WEST SUSSEX COUNTY COUNCIL CONSULTATION

TO:	Arun District Council FAO: Anita Gardner
FROM:	WSCC - Highways Authority
DATE:	5 July 2019
LOCATION:	Wicks Farm, Ford Lane, Ford, Arundel, BN18 0DF
SUBJECT:	F/30/18/PL 2 multispans tunnels, 2 ancillary outbuildings, drainage pond, associated drainage works, external hardstanding for vehicle parking, access and turning.
DATE OF SITE VISIT:	28/01/2019
RECOMMENDATION:	More Information
S106 CONTRIBUTION TOTAL:	N/A

DRAWING TITLE
AUTOTRACK VEHICLE TRACKING OF 16.5m HGV OF PROPOSED HGV MOVEMENTS WITHIN YARD AREA TO LOAD AND UNLOAD HGV

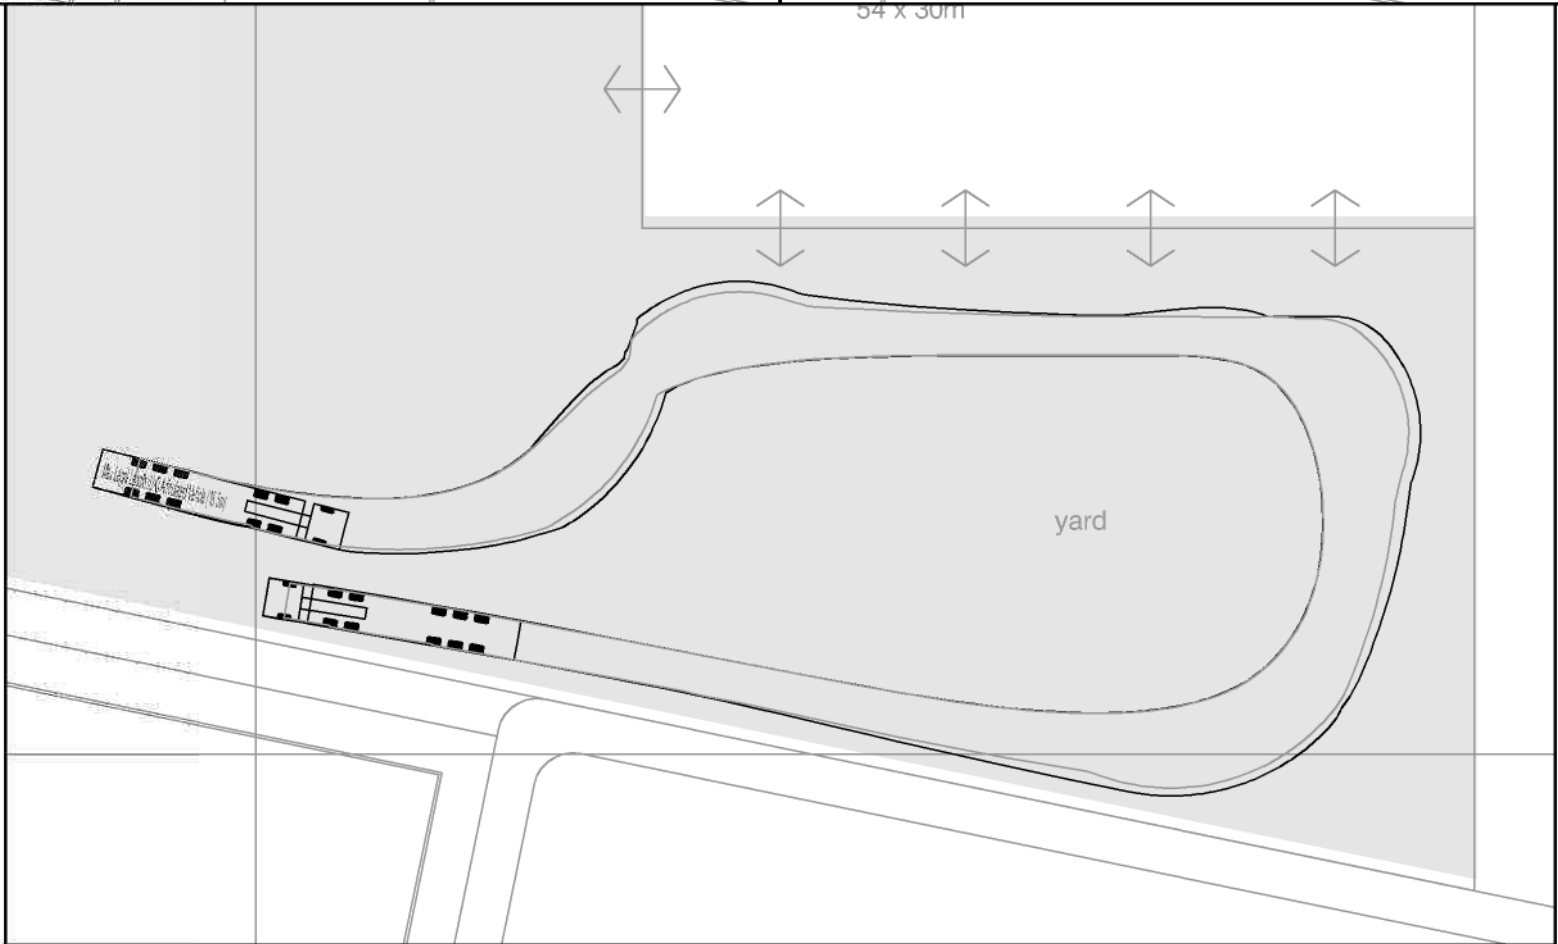
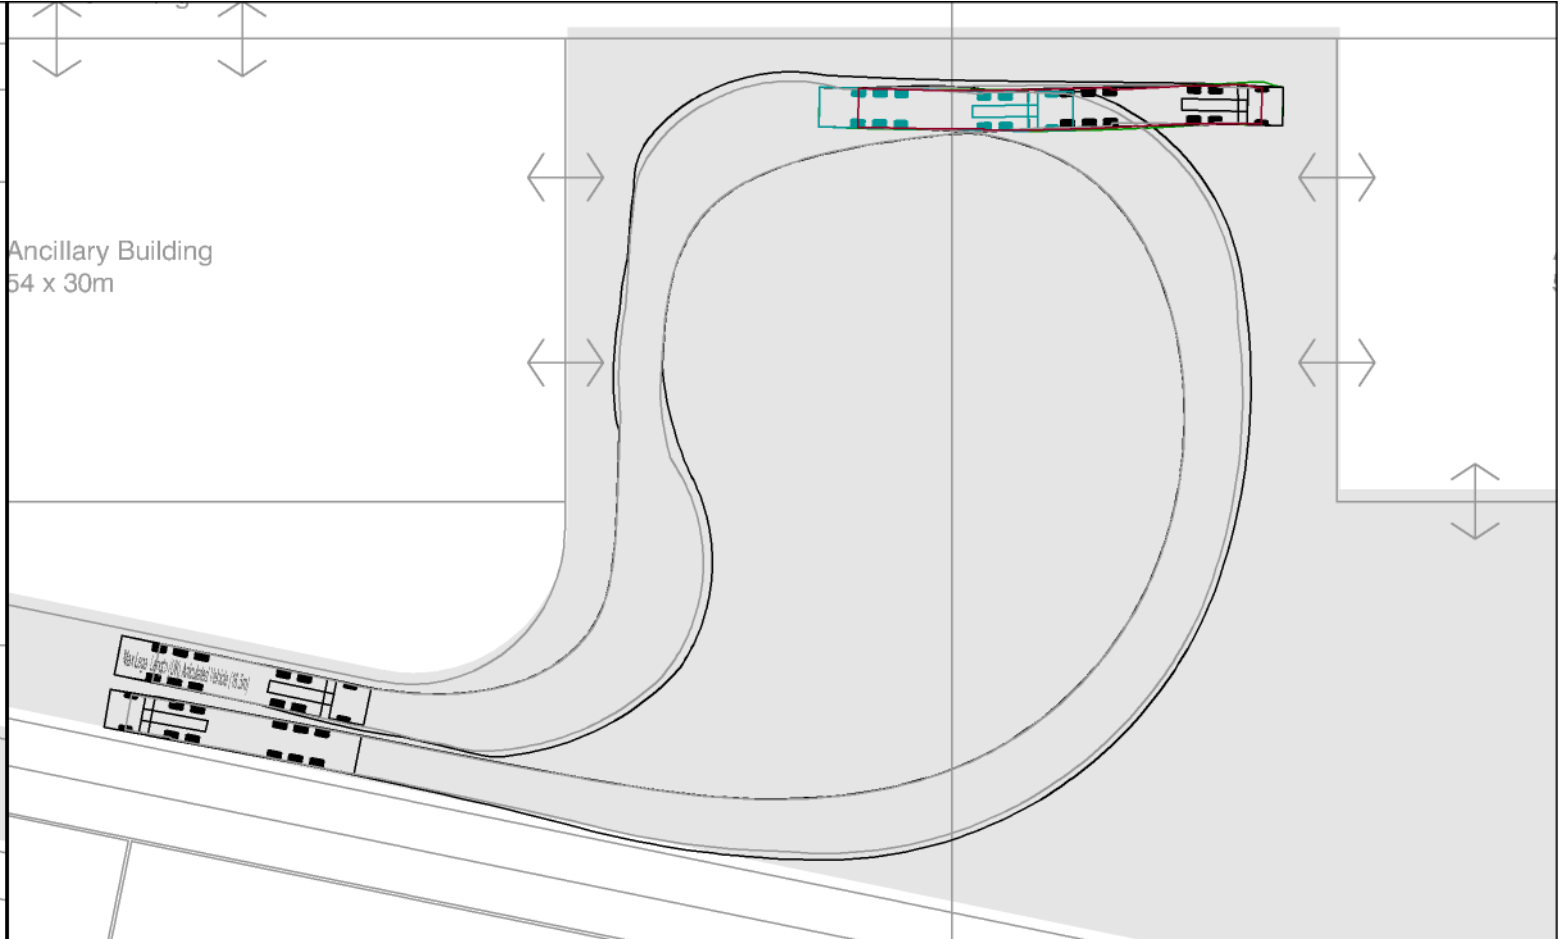
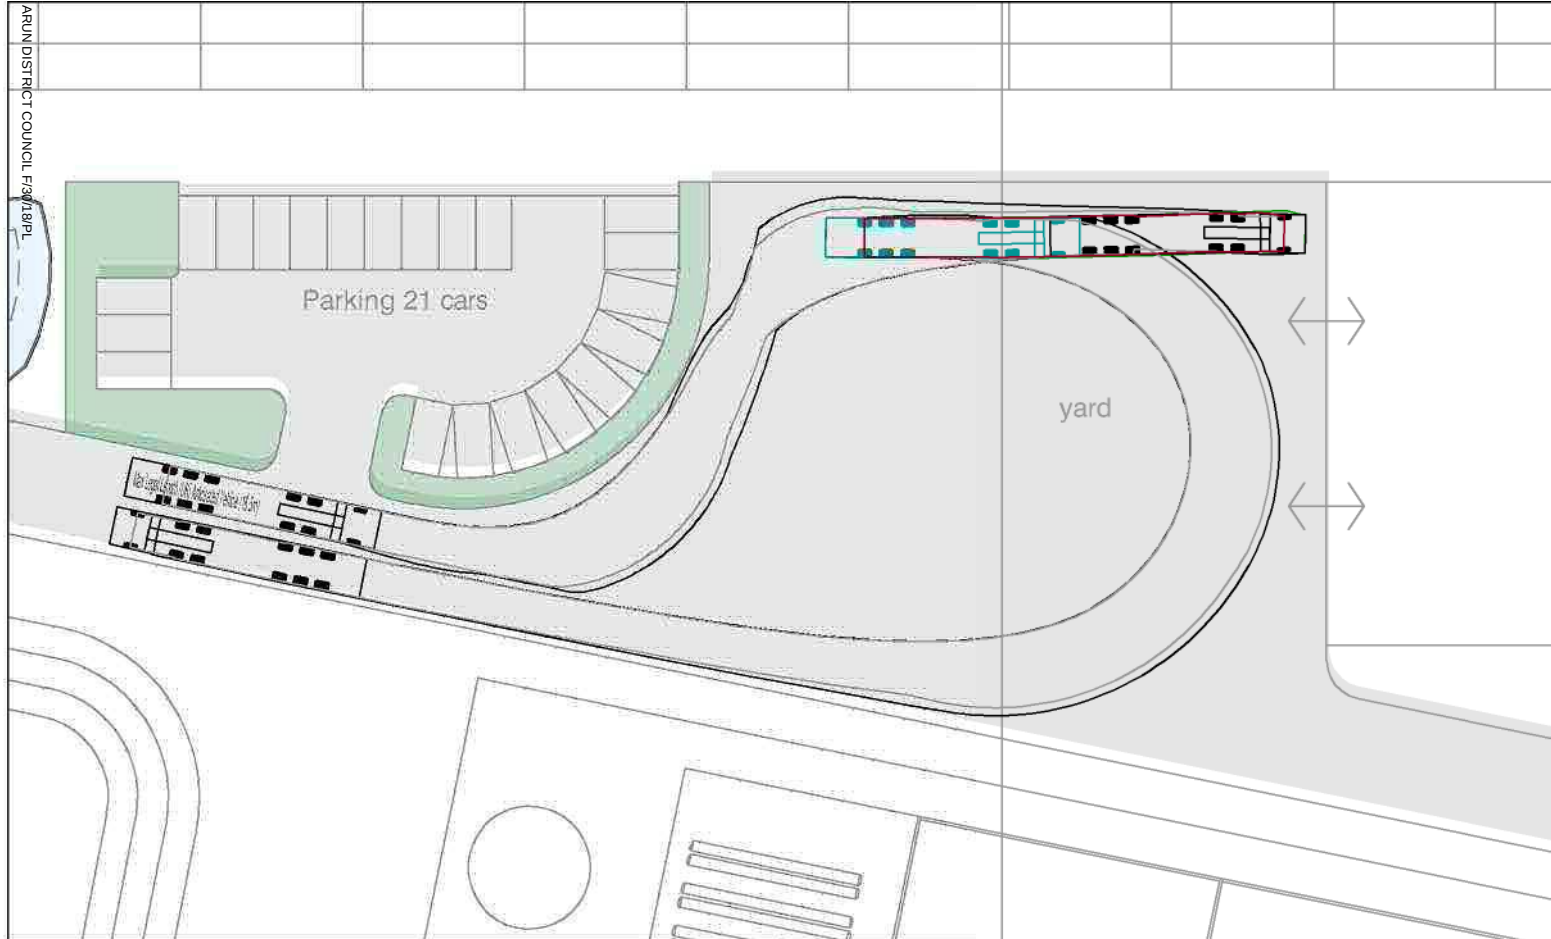
Swept path tracking should be provided demonstrating that the largest anticipated vehicle can enter and exit the site and turn on site. The swept path tracking should demonstrate the largest anticipated vehicle's movements from the road, for the entire length of the access road throughout the entire site and exiting onto Ford Lane in a forward gear. It is acknowledged that the applicant has demonstrated that HGVs will have sufficient space to turn on site; however, this should be shown as stated above, in relation to the vehicles' movements throughout the site.

WSSC does not maintain parking standards for the proposed use; however the applicant proposes 21 car parking spaces which considering there will be 16 support staff and some may car-share there appears to be sufficient space for staff parking. The proposed parking spaces meet minimum specifications of 2.4 x 4.8m and sufficient space is provided to enable vehicles to enter and exit each parking bay and turn. There appears to be sufficient space on site for passengers to be dropped off by minibuses. There also appears to be sufficient space for HGVs to park, load and unload; however as per comments above, full swept path of the largest anticipated vehicle is required for the *full length of the access and within the site*.
